February 17, 1998

RE: CONCEPTUAL DRAINAGE PLAN FOR DIRECT SERVICE (G16-D61) ENGINEER'S
STAMP DATED 1/21/98

Based on the information provided on your January 21, 1998 submittal, the above referenced site is approved for Site Development Plan For Building Permit.

CONCEPTUAL GRADING AND DRAINAGE PLAN

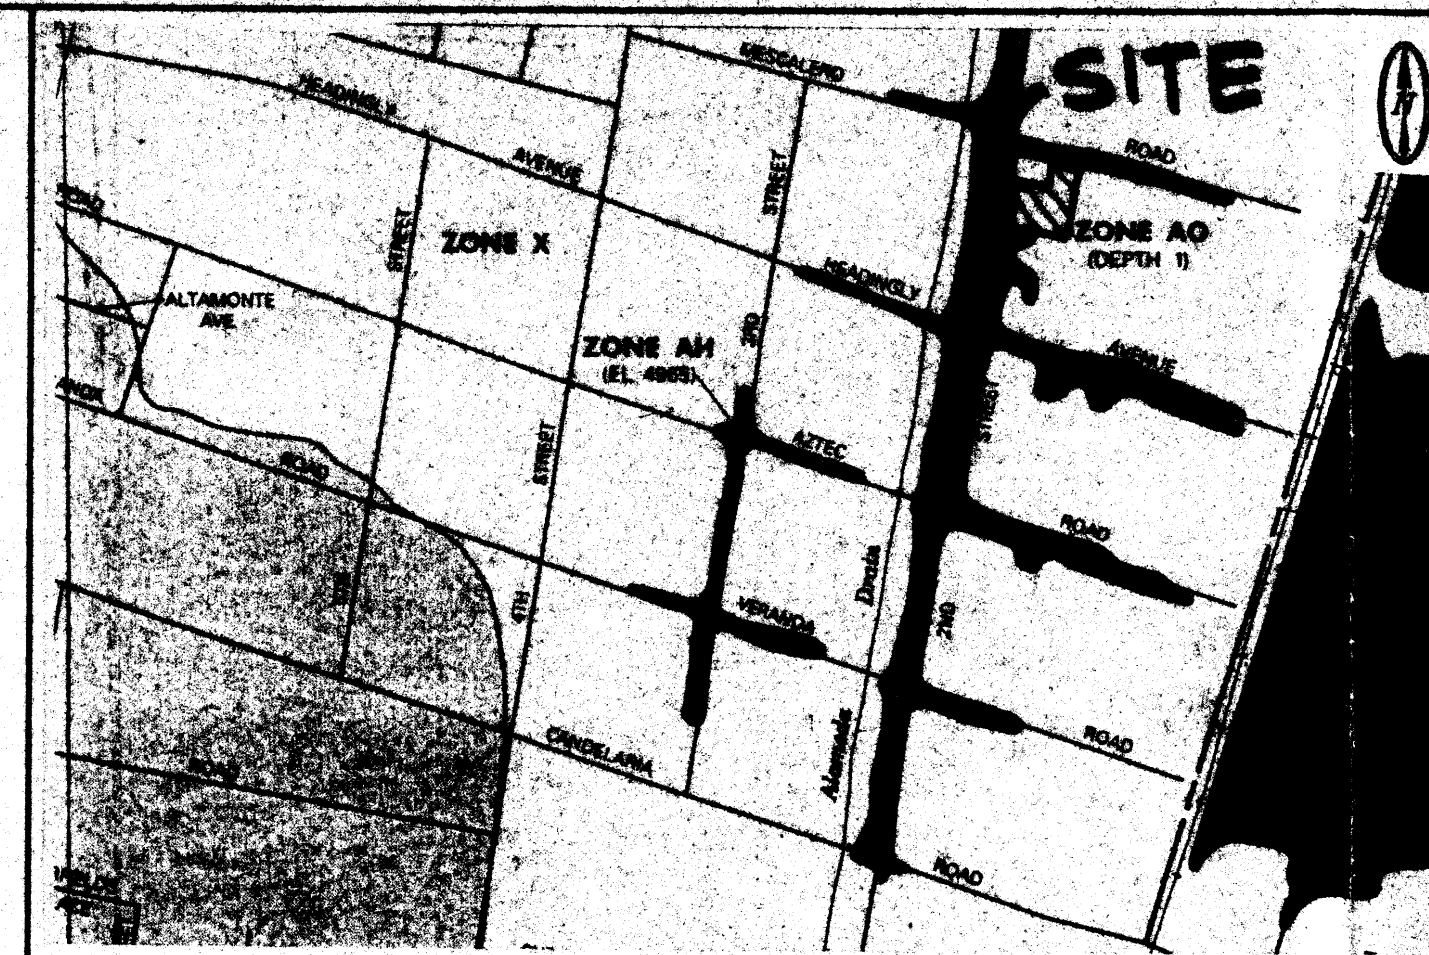
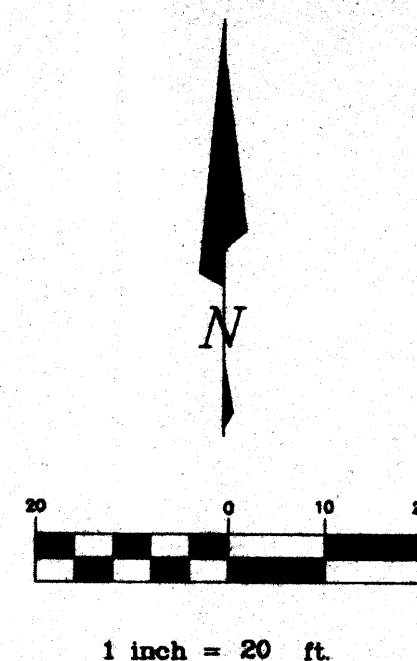
1. Top of curb elevations on both streets.
2. Swale slopes on the plan drawings.
